From: Colin Sharpe
Sent: 07 September 2011 13:58
To: Jane Tucker
Subject: FW: Consultation on planning application 3/2011/0611 Blue Trees, Copster Green

From: Hornby, Mark [mailto:Mark.Hornby@lancashire.gov.uk]
Sent: 07 September 2011 13:33
To: Colin Sharpe
Cc: ENV EPP Customer Service Area East
Subject: FW: Consultation on planning application 3/2011/0611 Blue Trees, Copster Green

drawing title:
 PROPOSED SITE PLAN

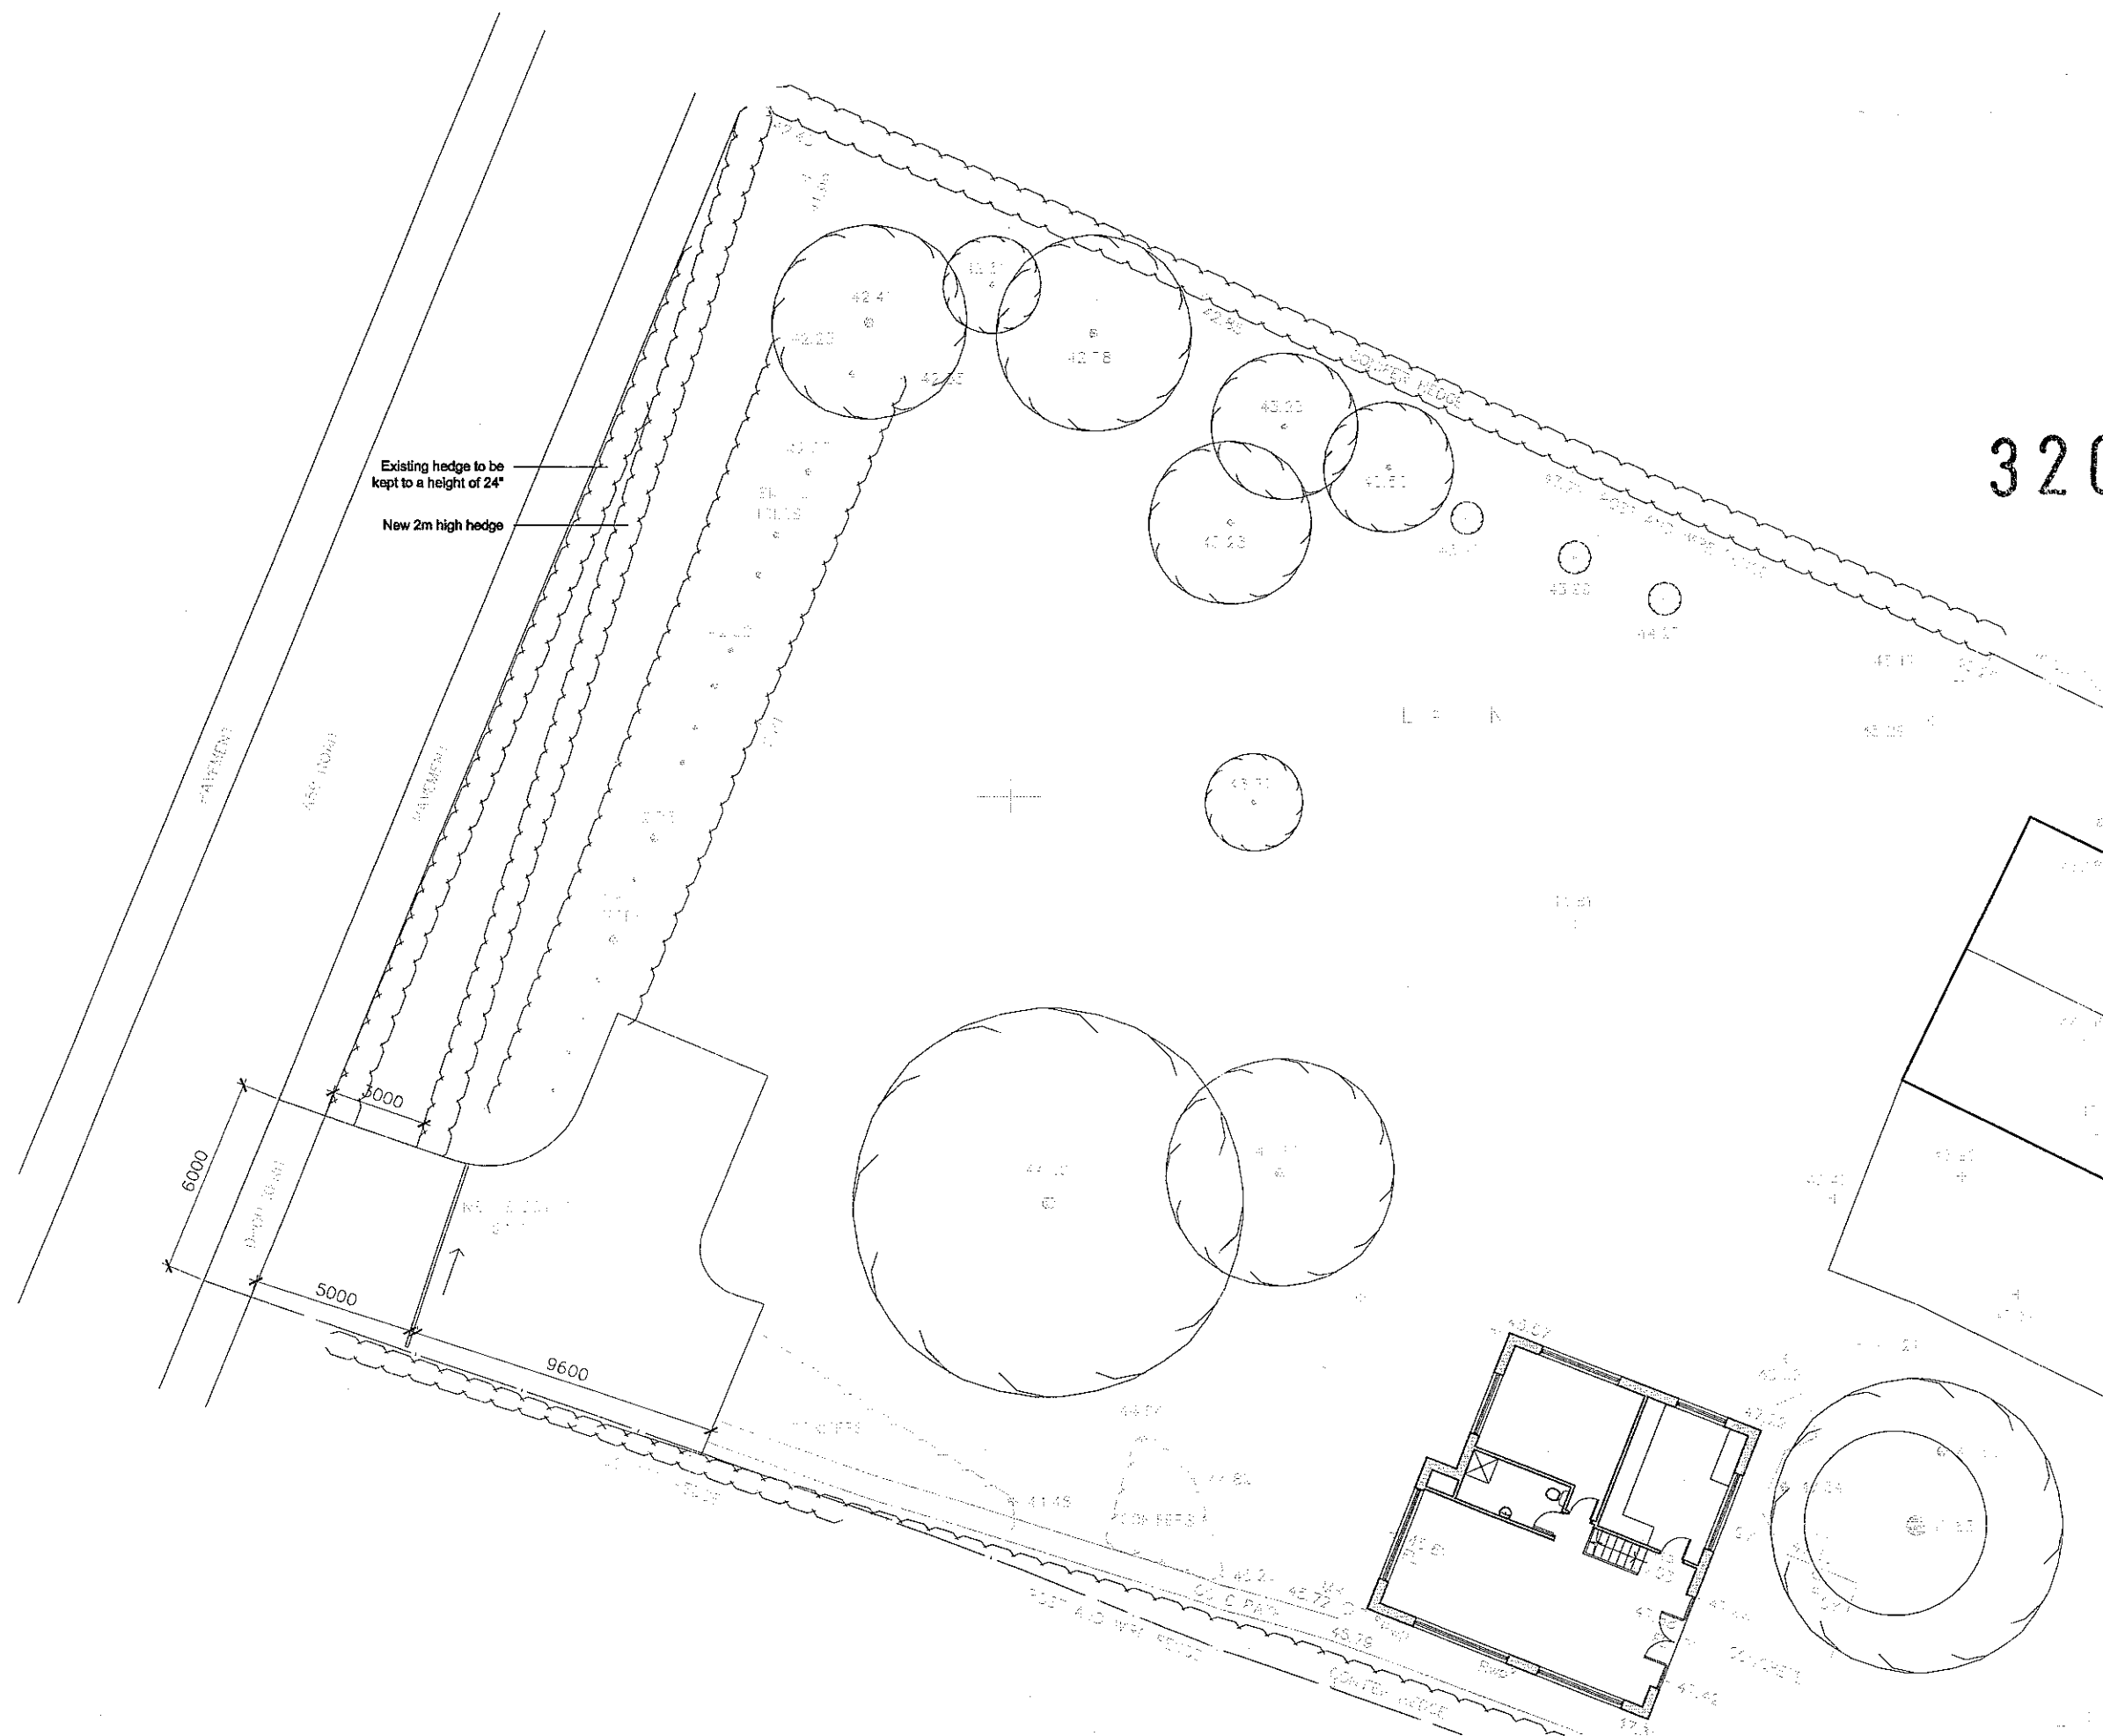
For a heavily trafficked road of this type with a 40mph speed limit I would require a new access point to provide a 2.4 metre x 90 metre visibility splay in both directions, as recommended in Manual for Streets 2 and the Design Manual for Roads and Bridges. The best visibility splay the applicant can realistically achieve to the east, the more critical of the two directions, is around 2.4 metres x 60 metres. This is significantly below what would be acceptable.

I therefore recommend a refusal of the application on highway safety grounds.
